Re: Y/63/19/RES - Bonhams Field, Yapton - 56 Dwellings,
Associated access and open space

Objection to the above application as follows:

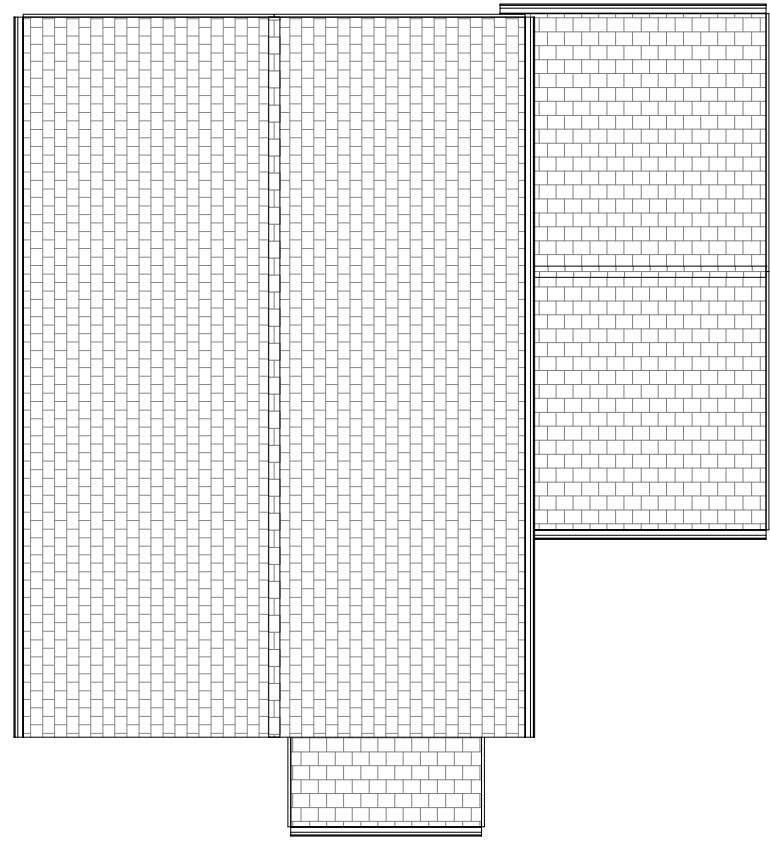
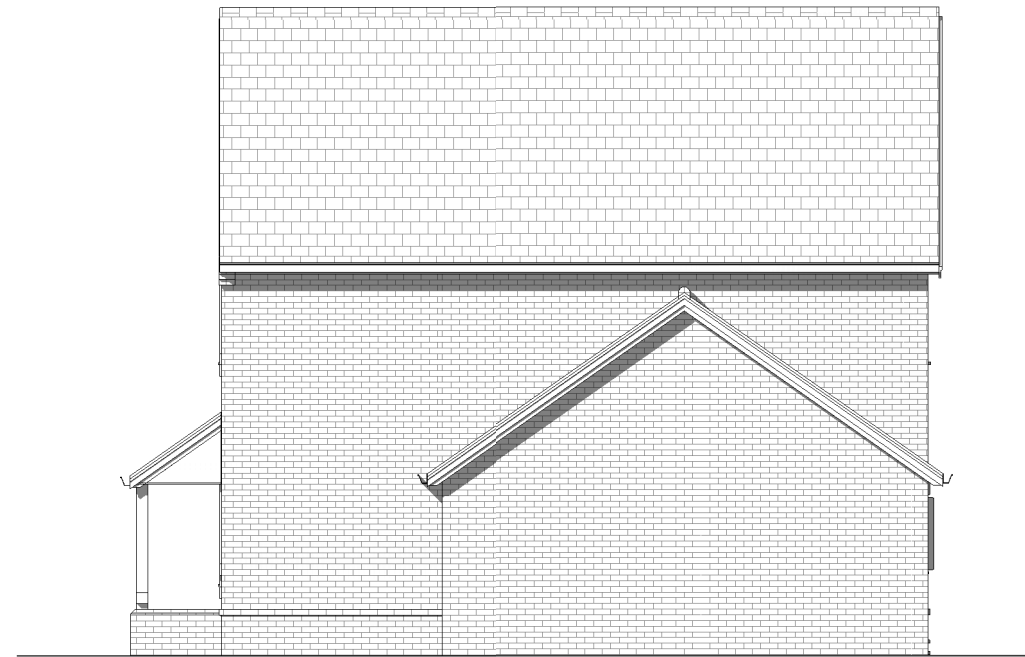
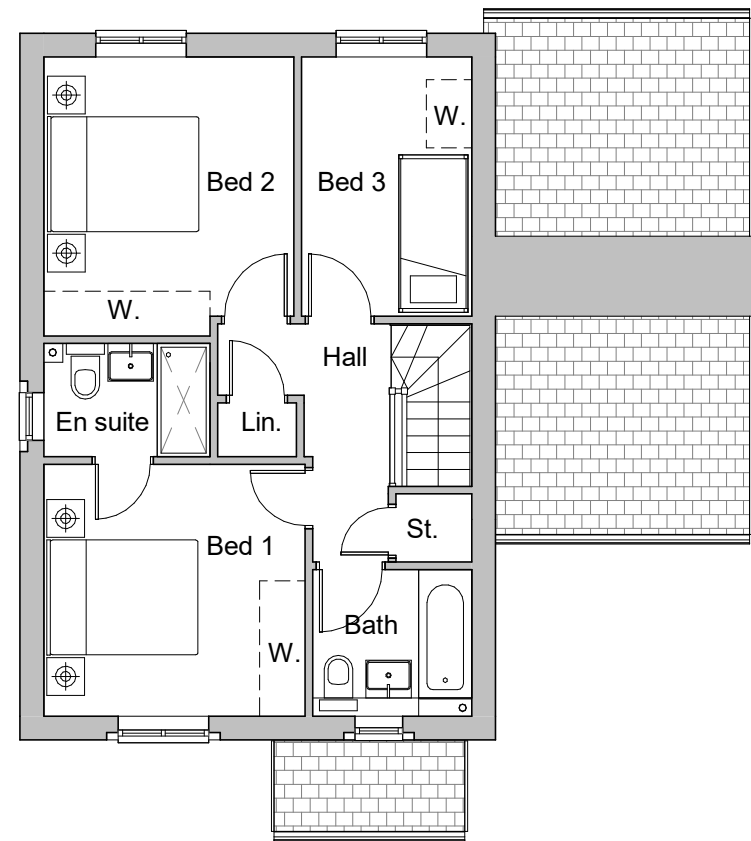
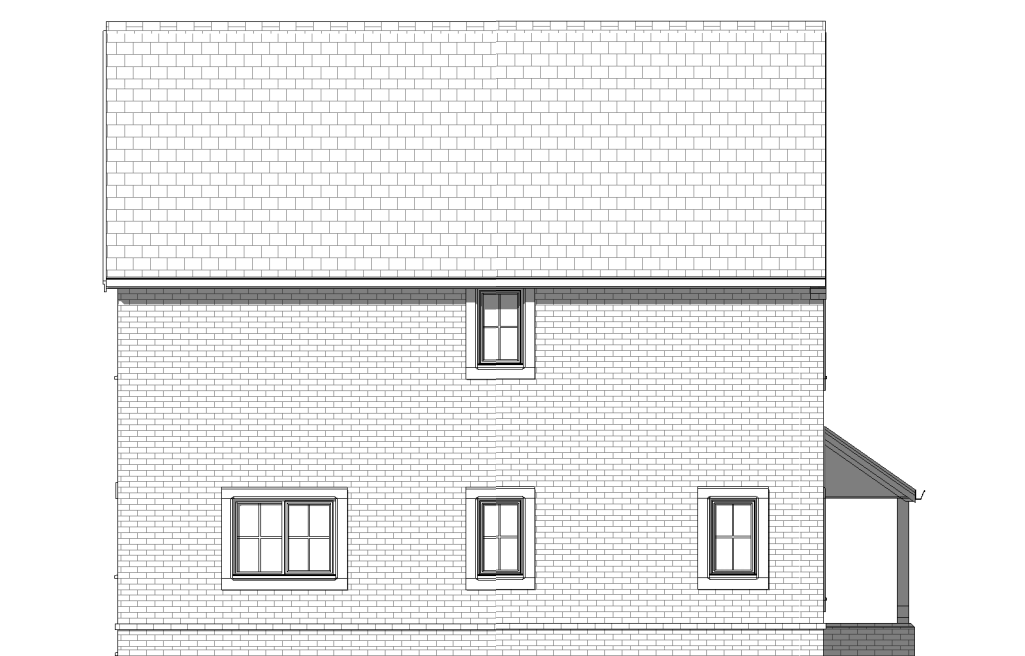
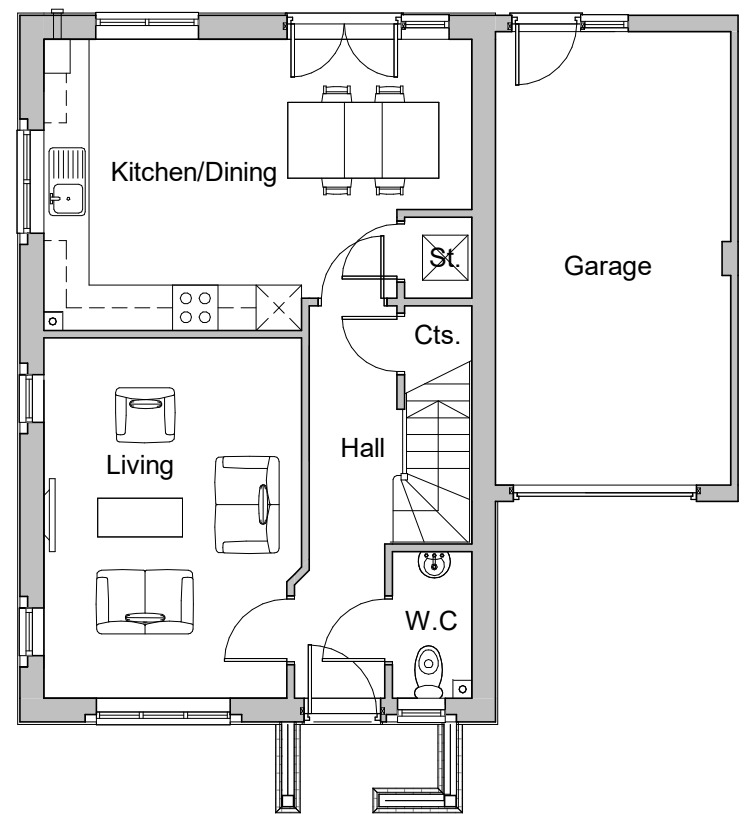
- 1) Minimal use of flint (1 of 19) and on single storey elements.
- 2) Too much use of red brick.
- 3) Tile hanging only visible on front of garage.
- 4) Plots 27, 28 & 29 face plots 30, 31 & 32 - typical cul-de-sac.
- 5) Entrance road plots 1, 2 & 3 are too close to the road. Reduce to 2 and set back - will ensure visibility.
- 6) Repeat of limited styles and design.
- 7) Visitor parking not defined.
- 8) Detailed landscaping plan required - open space, trees along C.A. border to ensure privacy.
- 9) Level of site rises - roof heights important, ?? Bungalows?
- 10) Loss of amenity to all nearby properties with constant Building noise from c.7.30am, lorry traffic, reversing beeps.
